Your Ref
LU/29/14/
Our Ref
PLAN-005659
Date
27/03/2014

Proposal: Extension to existing steel framed purpose built industrial unit plus overlaid existing brick & corrugated building with finishes to match new extension.

Site: Unit 1 Lineside Way, Lineside Industrial Estate, Littlehampton, BN17 7EH.
LU/29/14/

Title: Plans and Elevations
- Existing & Proposed

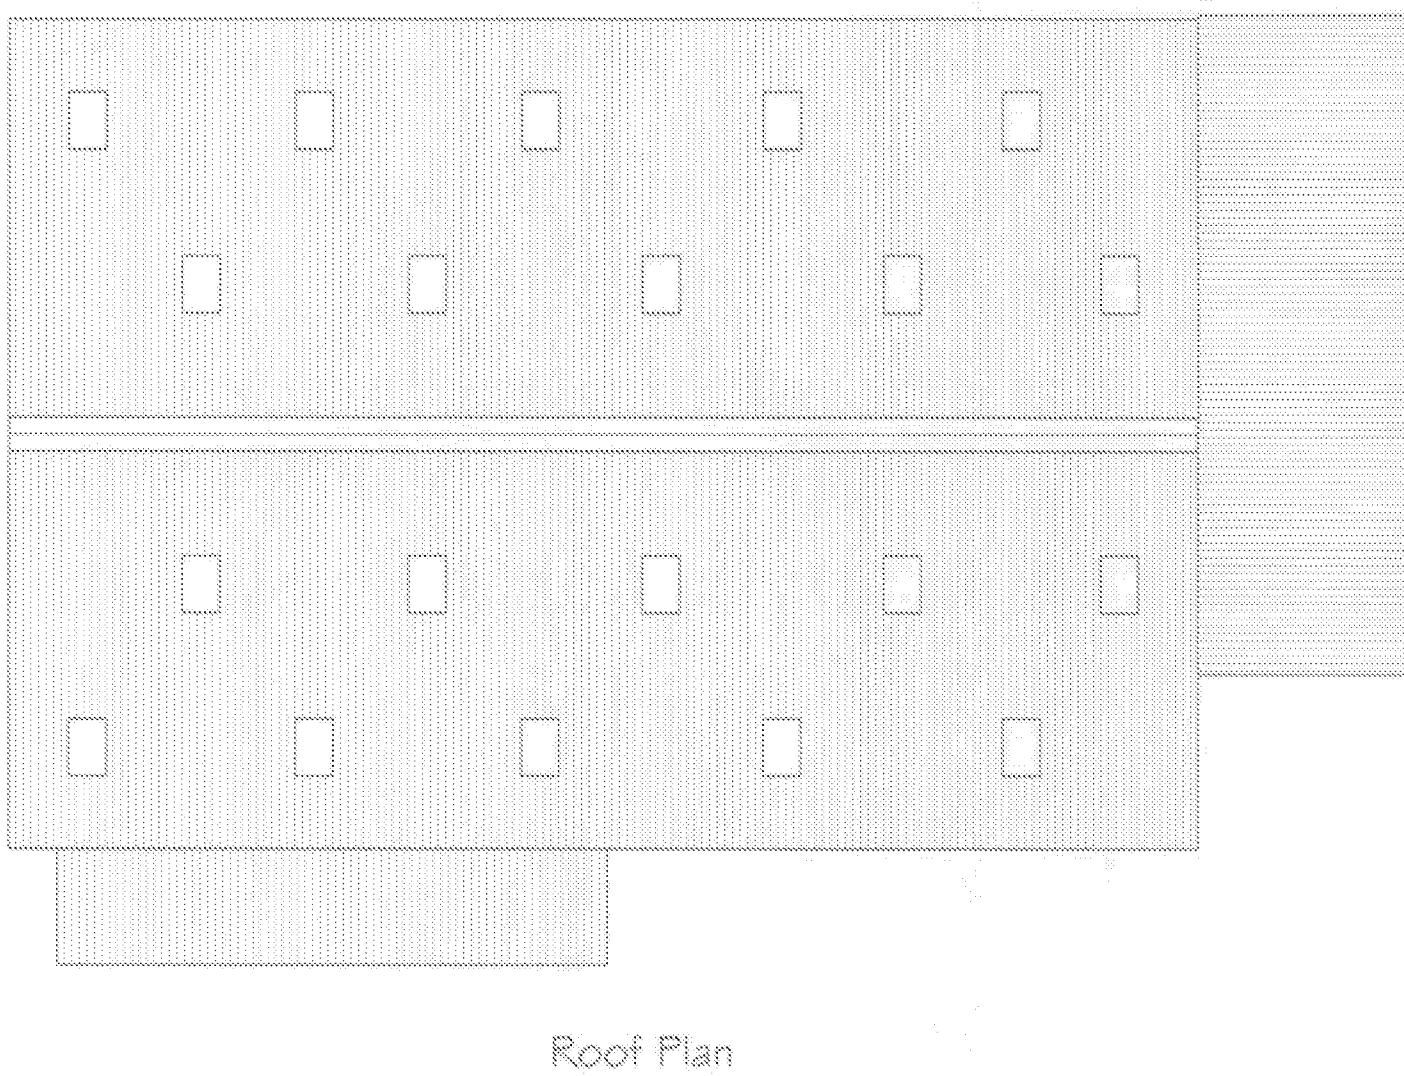
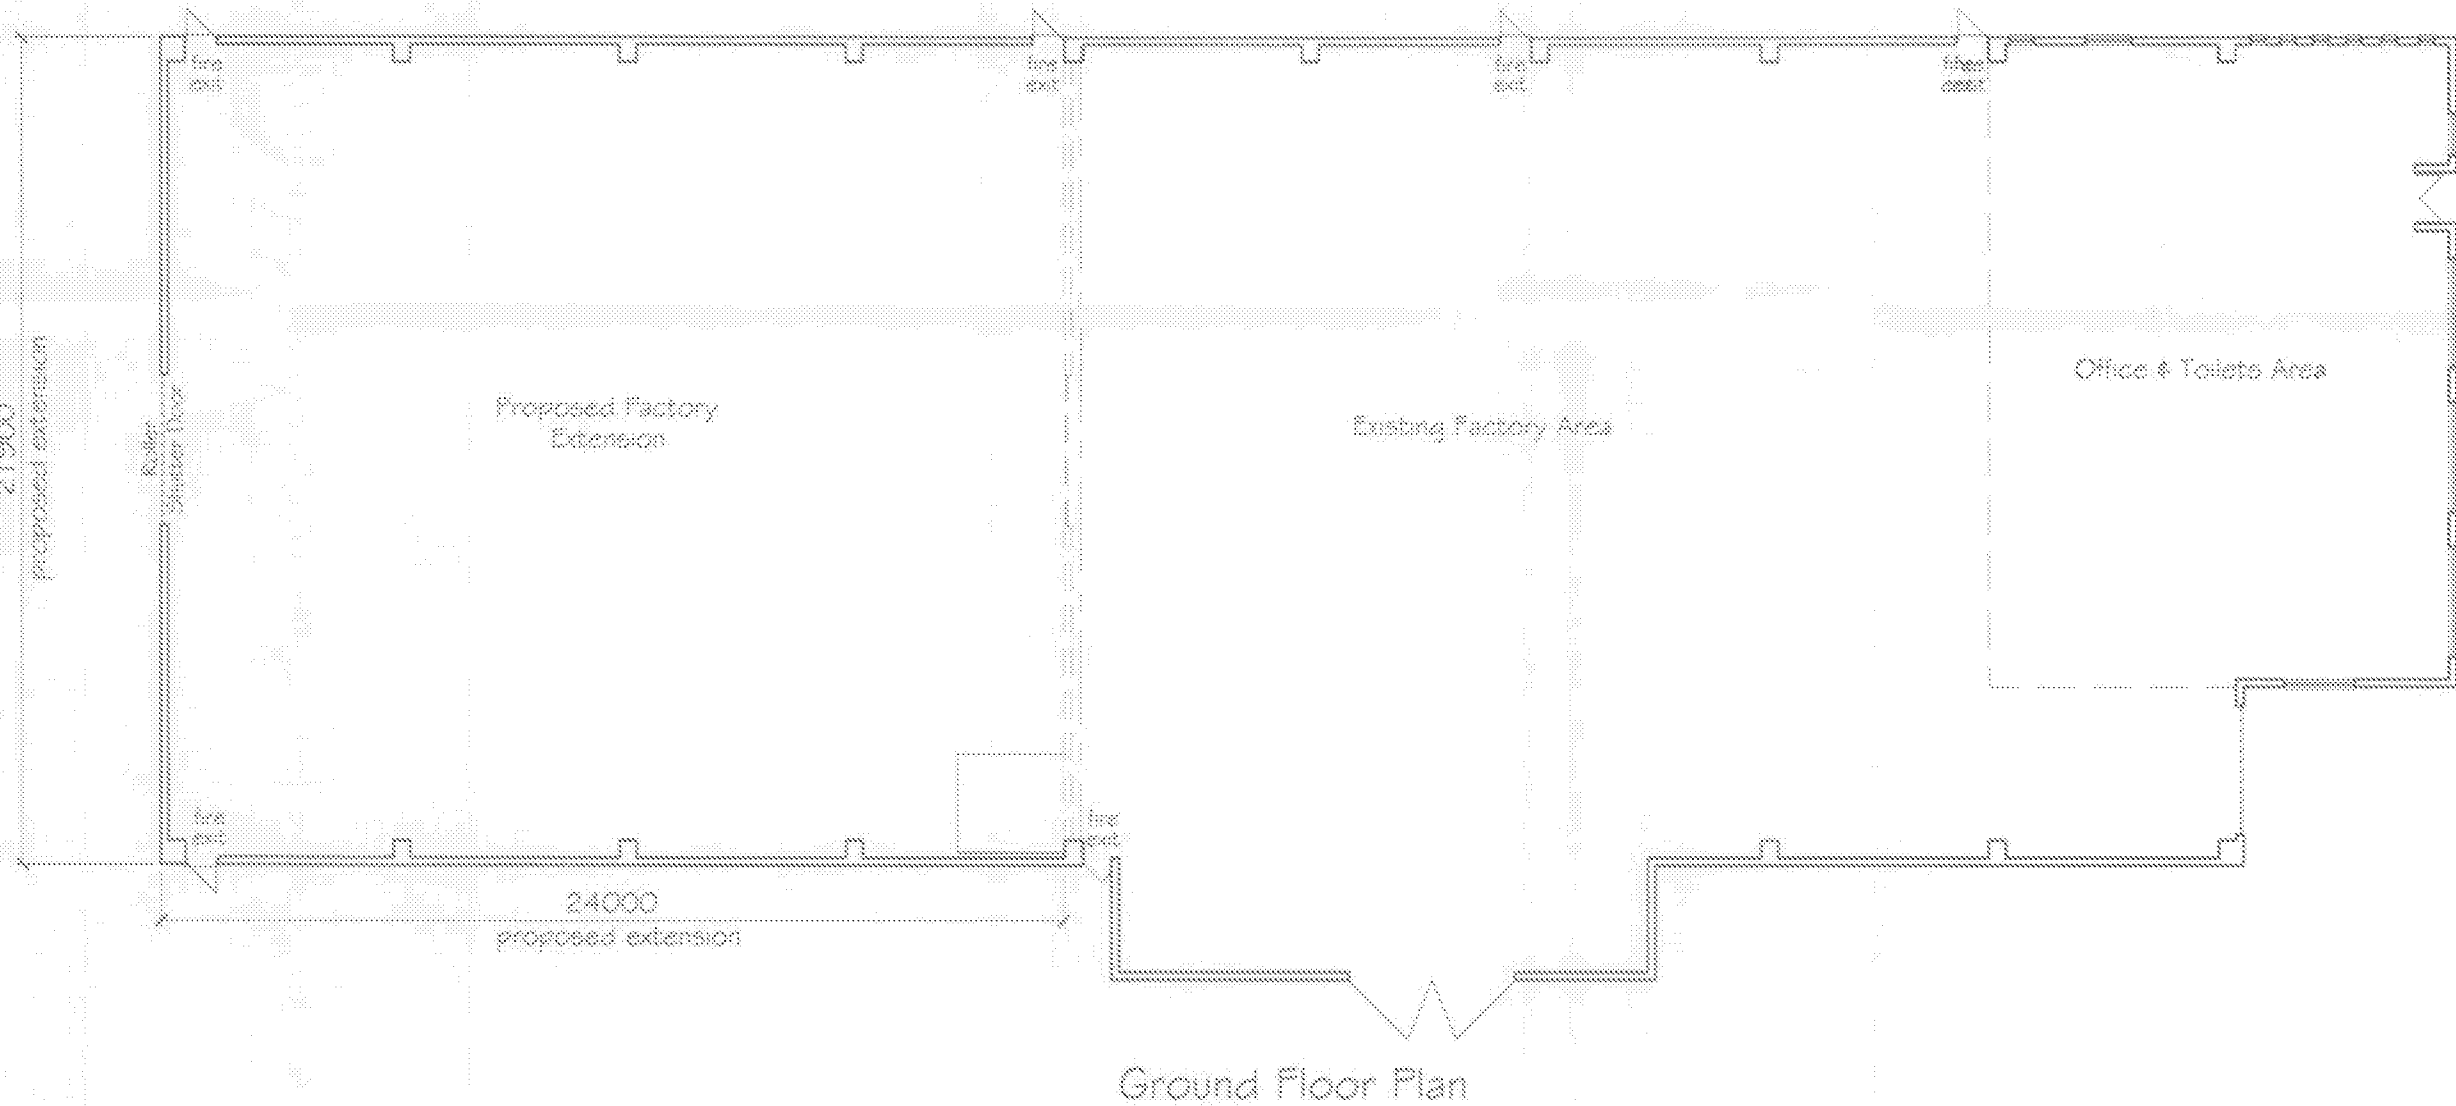
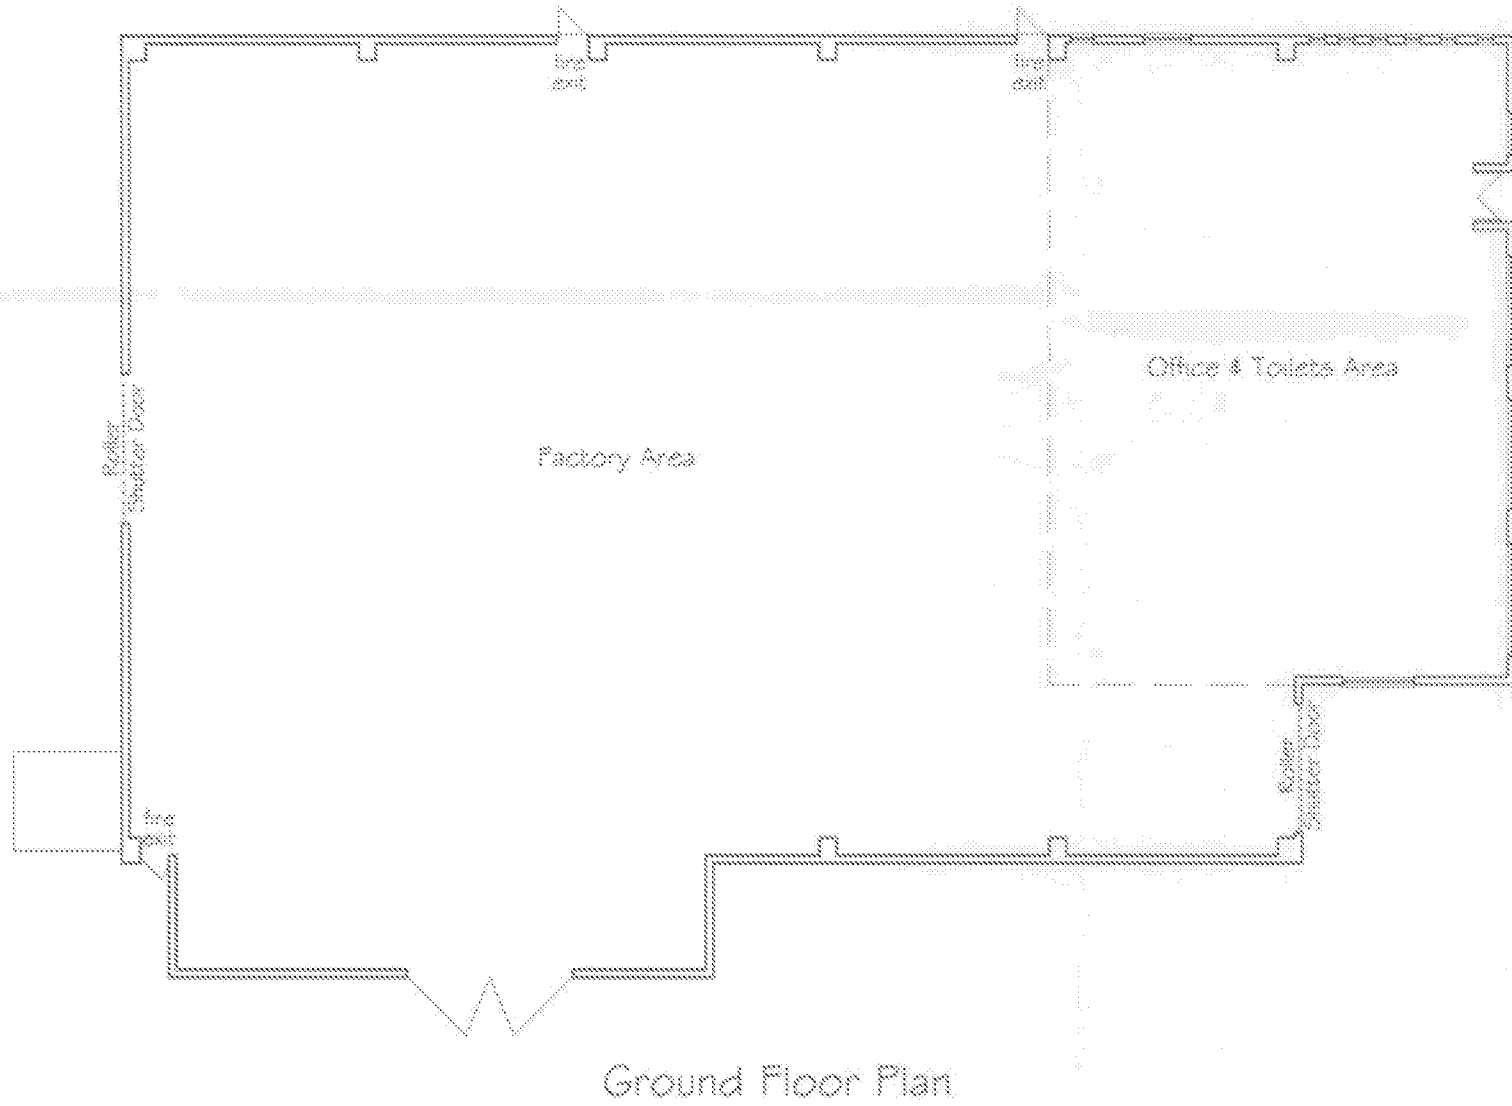
It appears that the developer is intending to build close to a (BAC) public foul sewer which is crossing the site. Building over a "public sewer" is not normally permitted by Southern Water.

However, under certain circumstances building over a sewer may be allowed. The conditions associated with the buildover/close to a sewer are contained in Southern Water guidance notes which are available at: www.southernwater.co.uk. A formal application to build close to the sewer will required to be submitted by the applicant

In order to protect drainage apparatus, Southern Water requests that if consent is granted, a condition is attached to the planning permission. For example "The developer must advise the local authority (in consultation with Southern Water) of the

measures which will be undertaken to protect the public sewers, prior to the commencement of the development.”
